## Department's Comments

DRAWING TITLE:
MECHANICAL SERVICES
STAGE 1 - WASTE TREATMENT FACILITY
GROUND LEVEL VENTILATION LAYOUT
9 WHYALLA PL

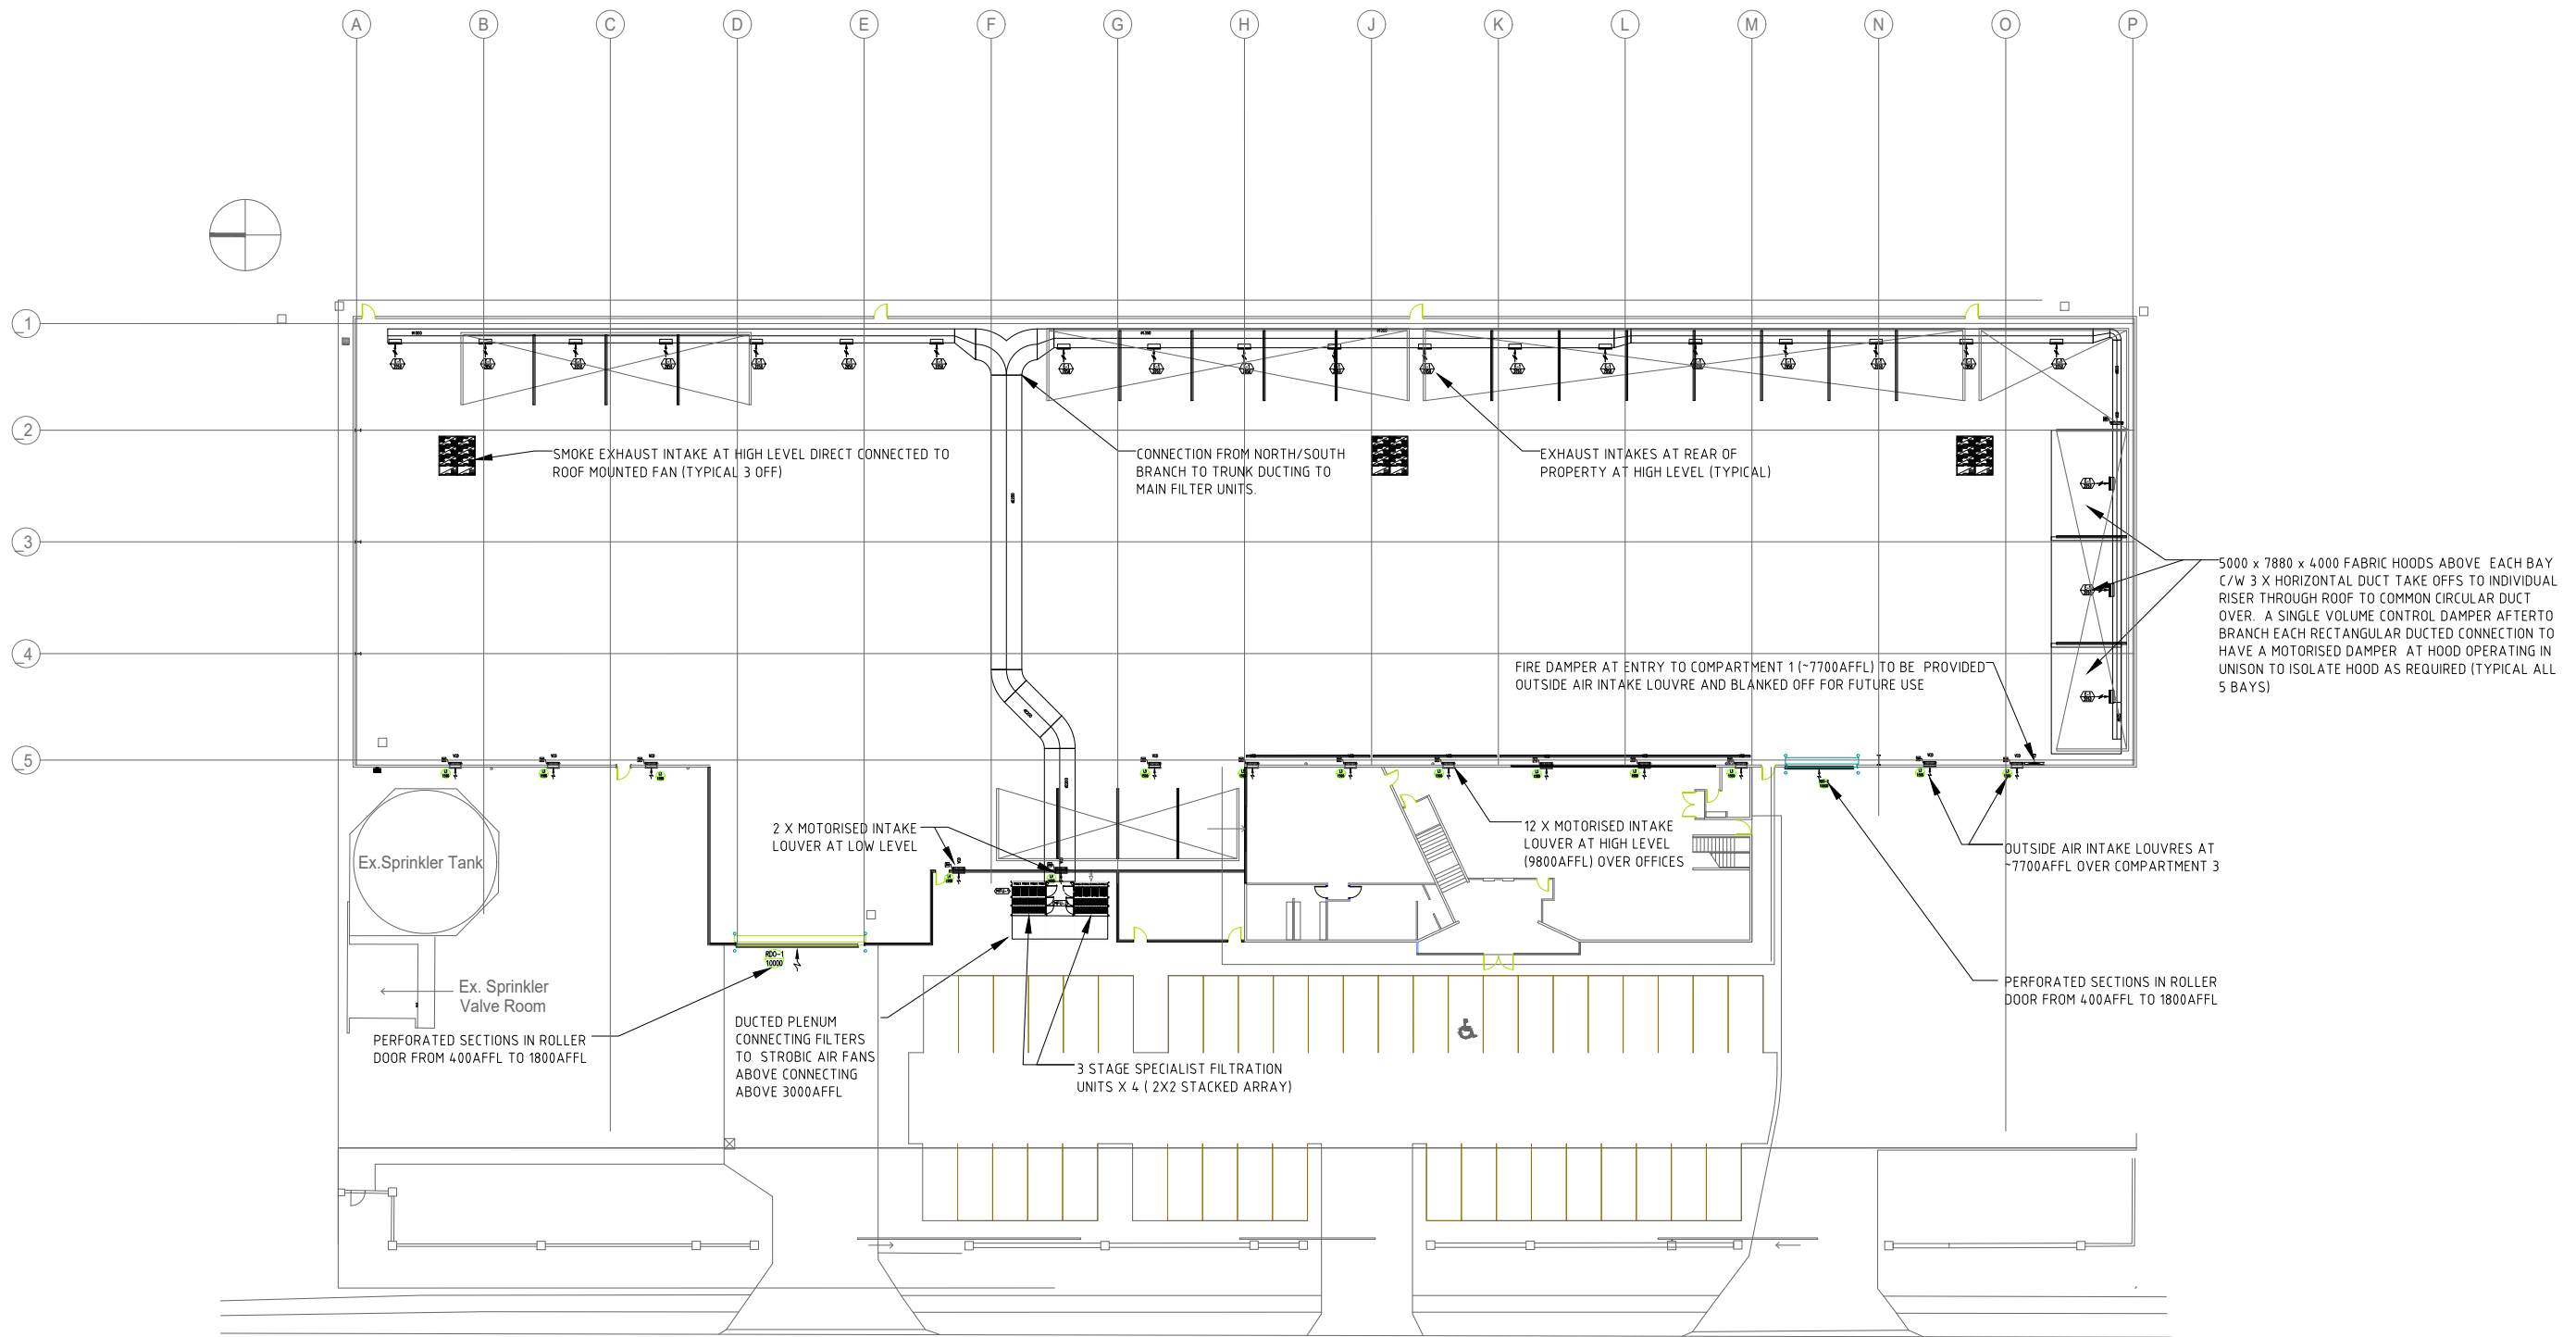
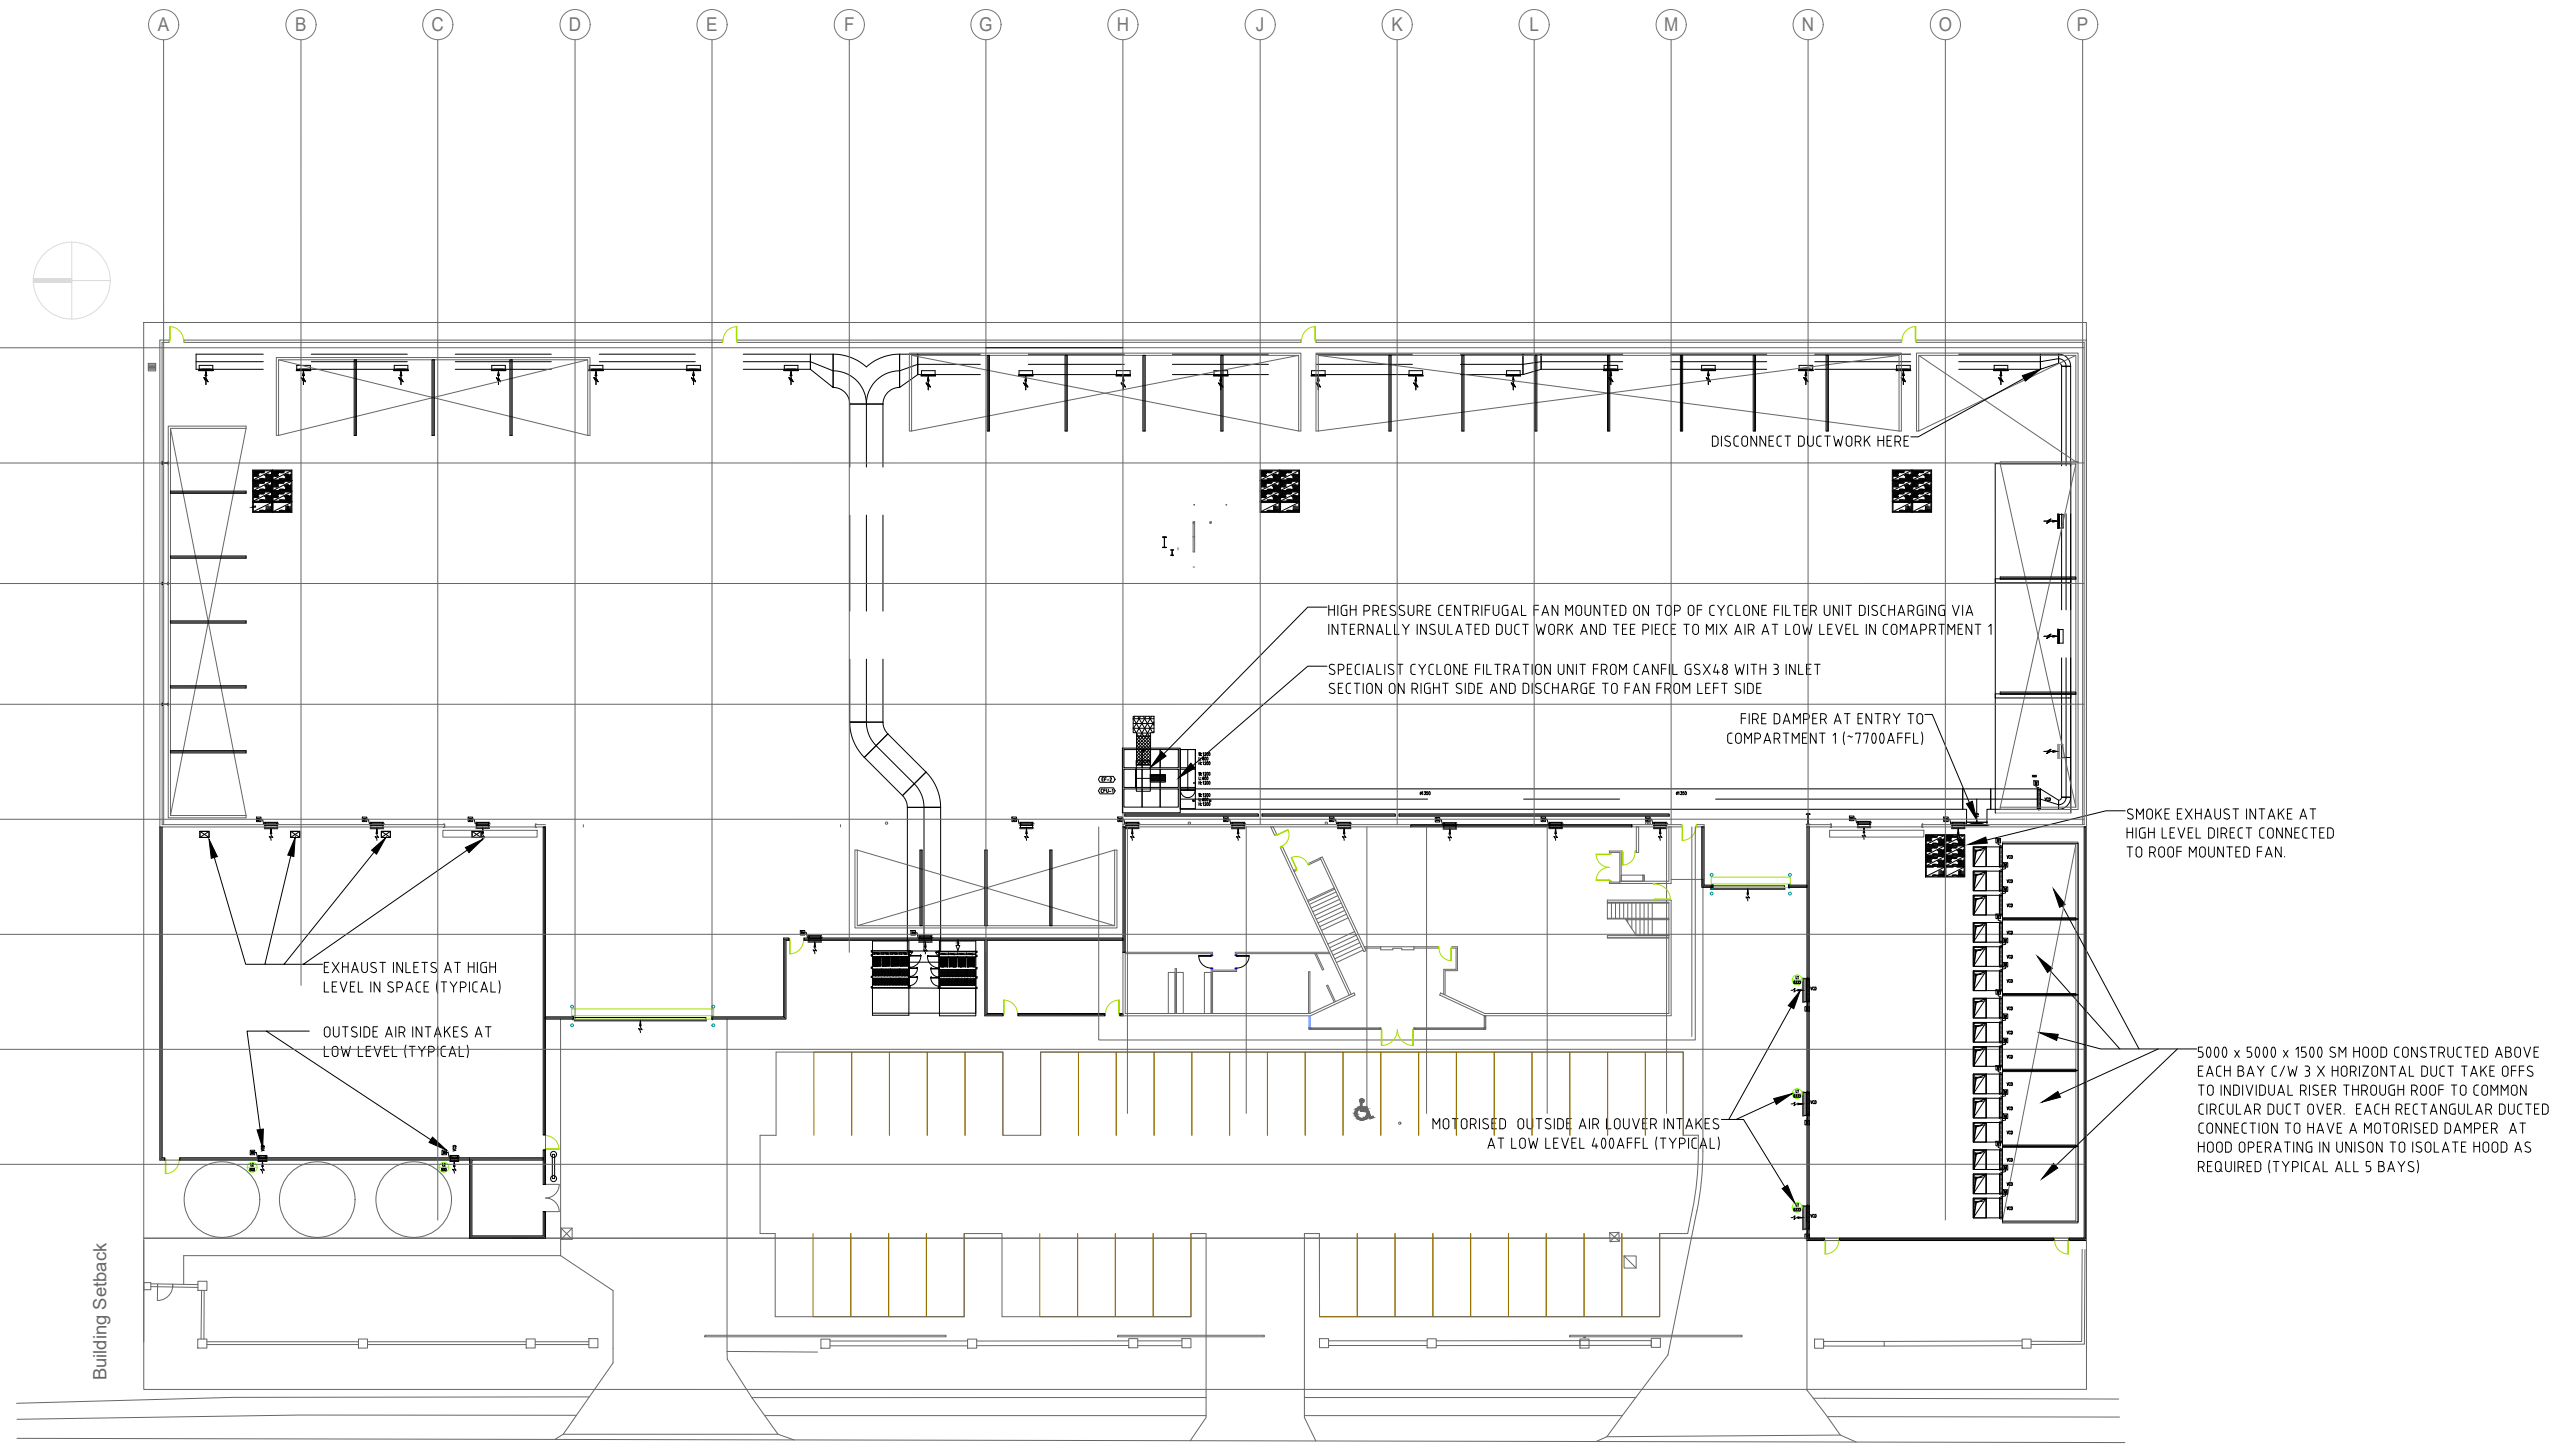
- Provide justification that the building has been constructed to maintain negative pressure and avoid emissions permeating through joints in the concrete tilt panels.

Title
GROUND FLOOR PLANS - EXISTING & PROPOSED

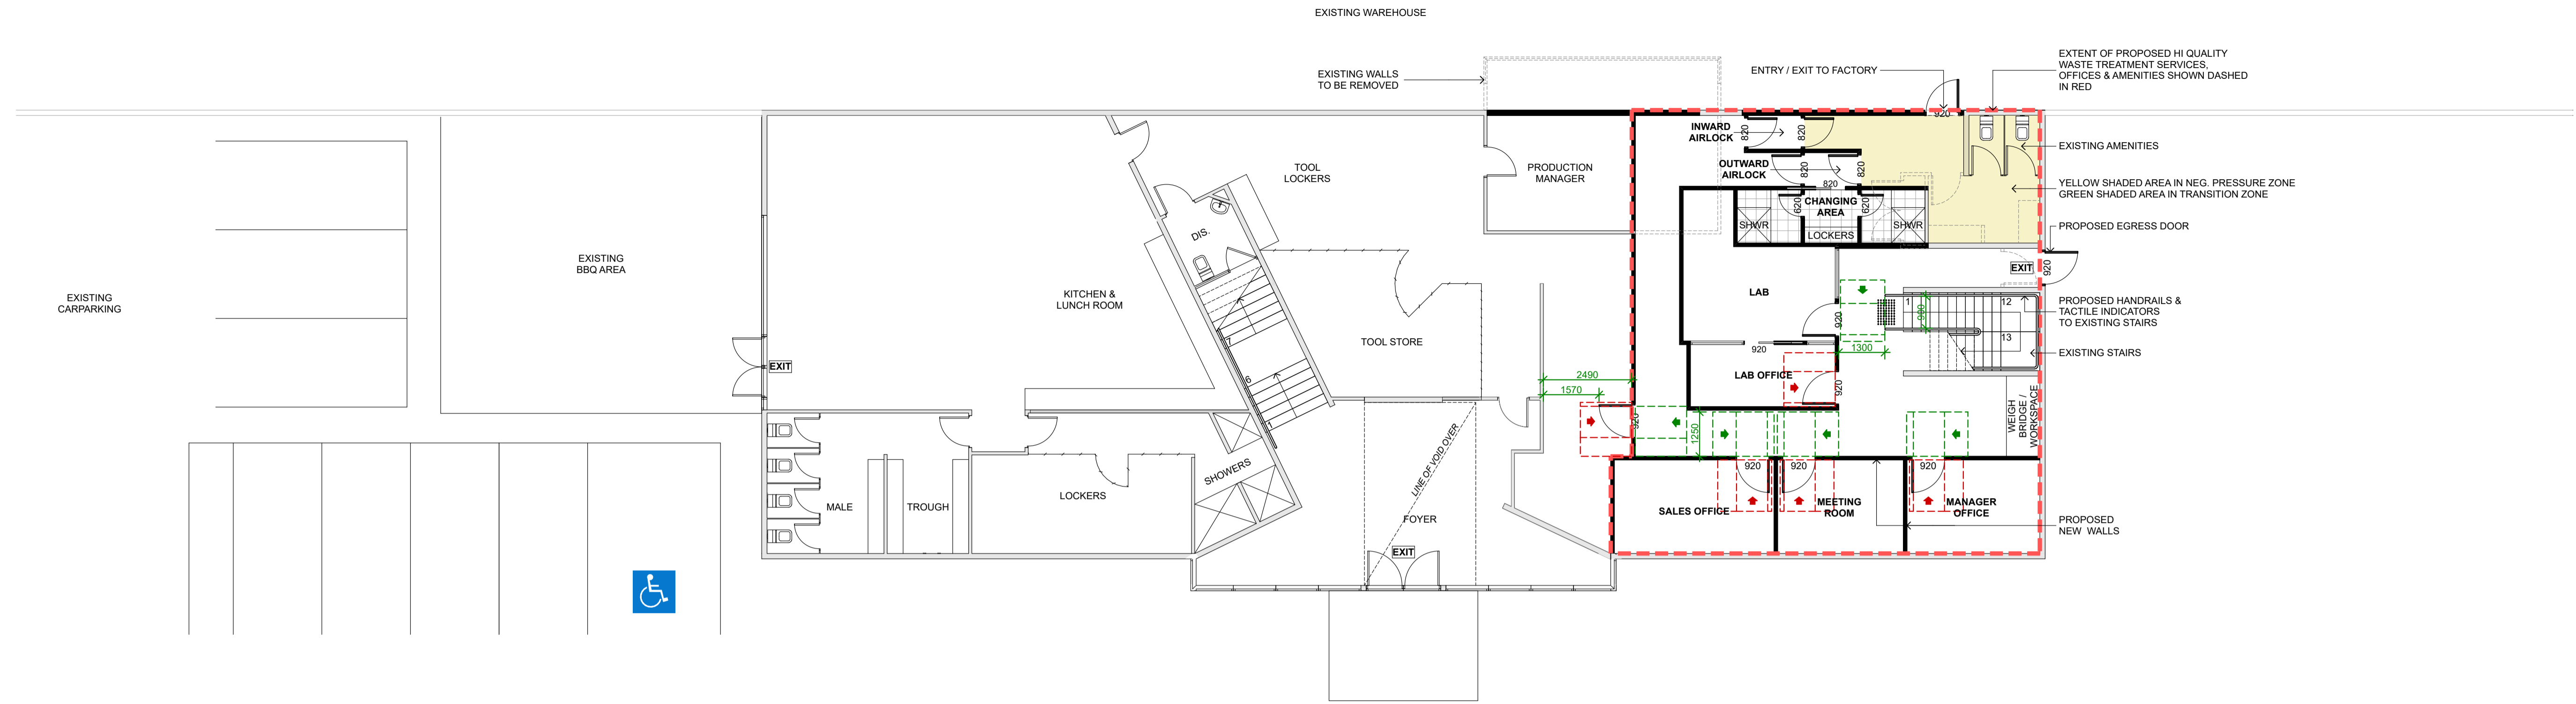
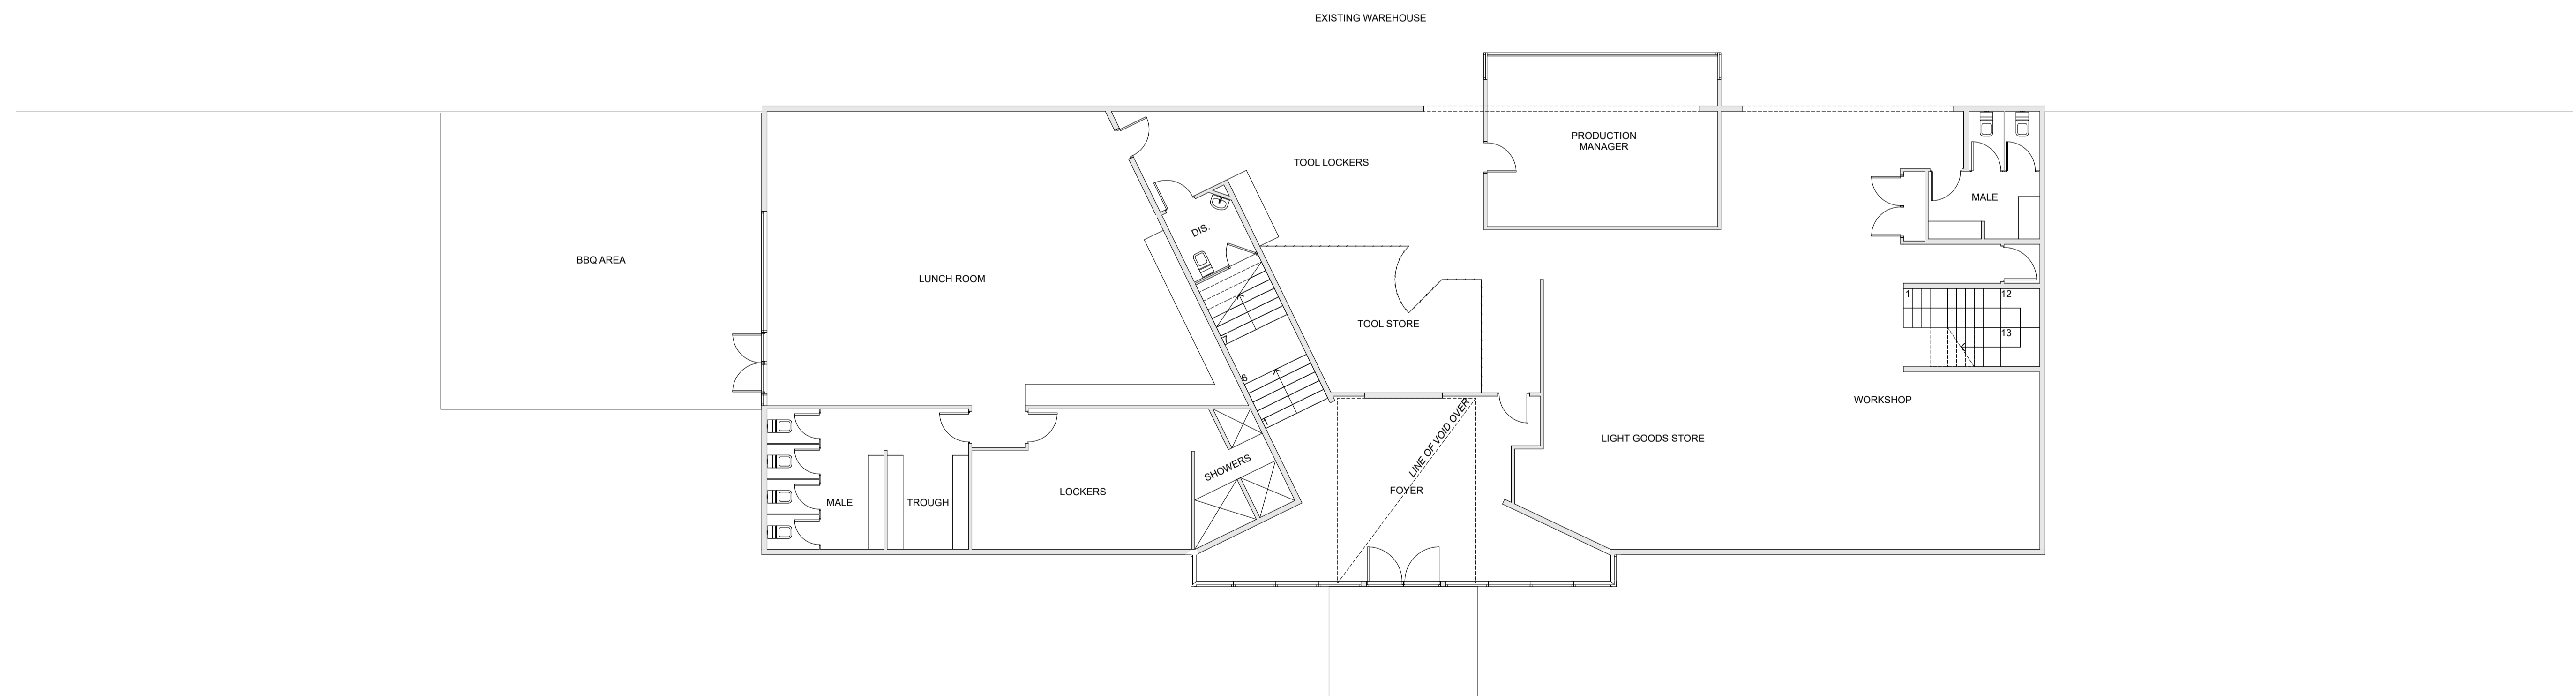
- Provide the maximum storage capacity of waste within the building at any given time including proposed tonnage capacities for each bunker.
- Provide a floor plan detailing the stockpile areas for all wastes to be stored on site listed in Appendix C of the EIS, the location of all processing areas, and an indicative location of plant, equipment and other treatment technologies.

- Provide details of the leachate / contaminated water conveyance system including detailed plans.
- Provide the safeguards proposed to ensure cross contamination of wastes are avoided.
